From: Roger Evans
Sent: 24 October 2011 18:17
To: Mark Peacock
Subject: Proposed development at Salisbury Square *S6/2011/1994/MA*

Roger Evans
Chartered Environmental Health Practitioner

DRAWING TITLE:
Site Plan

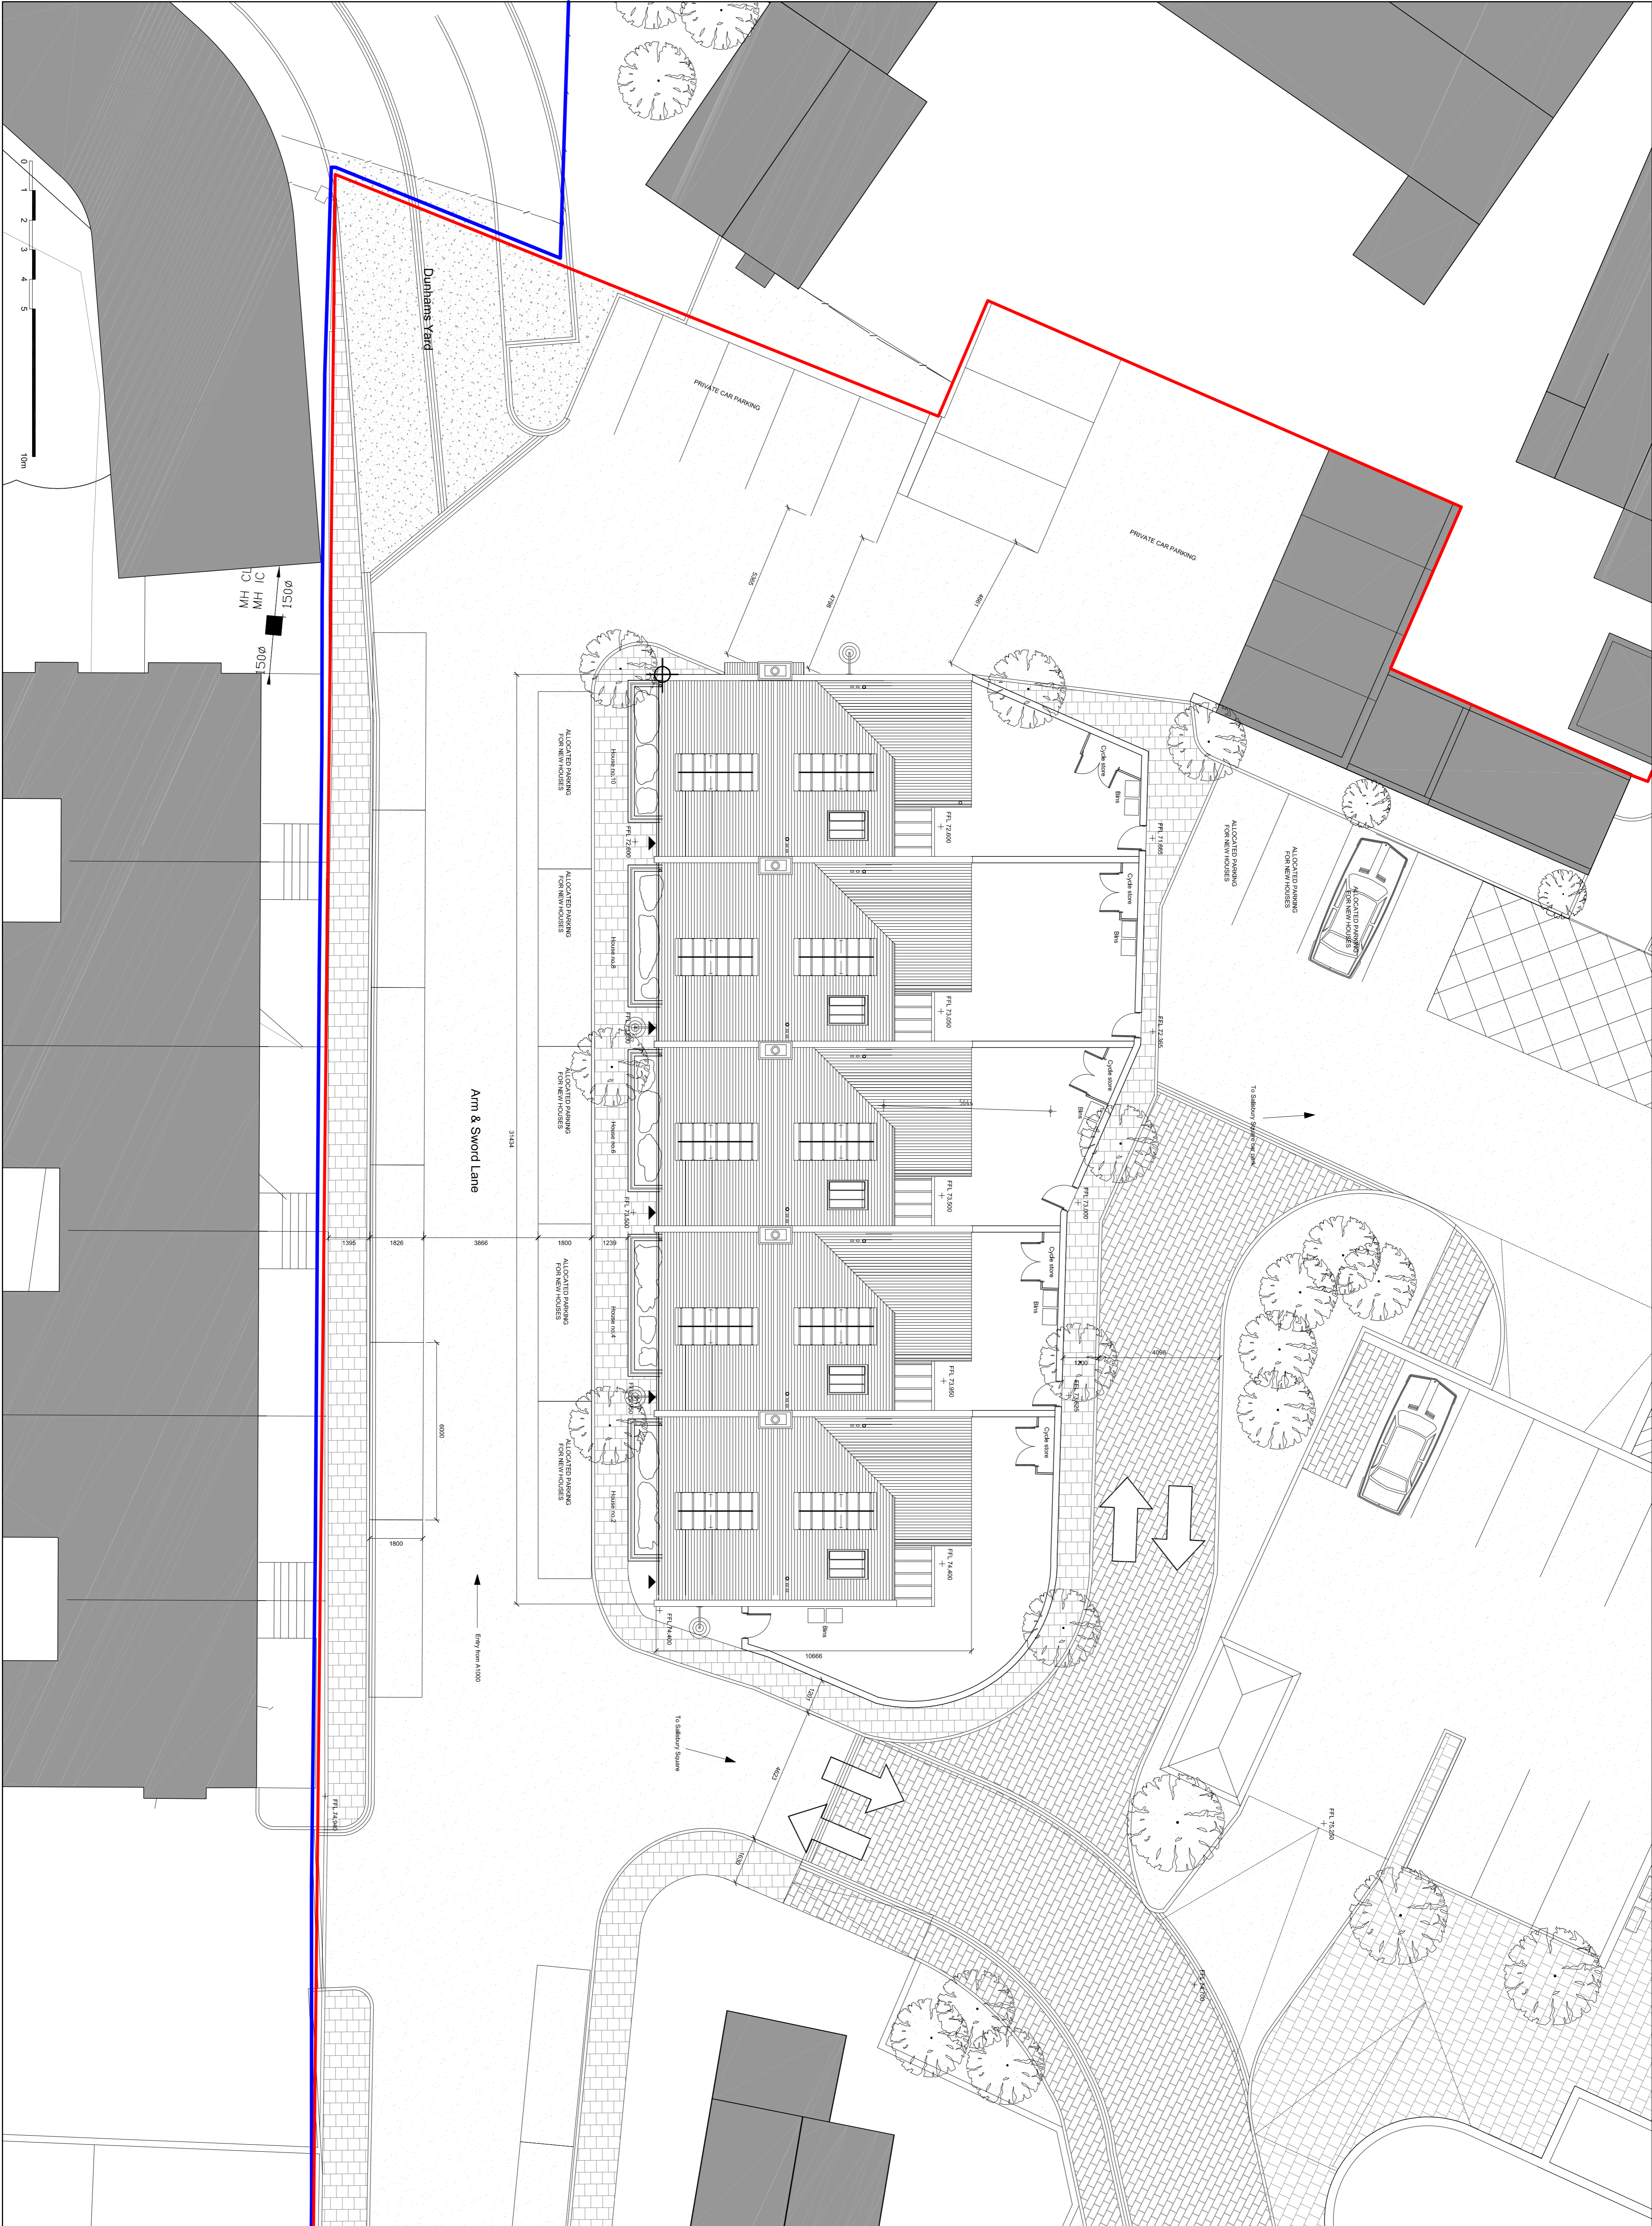
As I said in my brief phone call, I am concerned there is no noise report because the proximity of the Great north road and the railway line may well be an issue in terms of noise exposure to some of the facades. Also the issues of the houses, surrounded by car parking and the demolition plan will need some consideration.
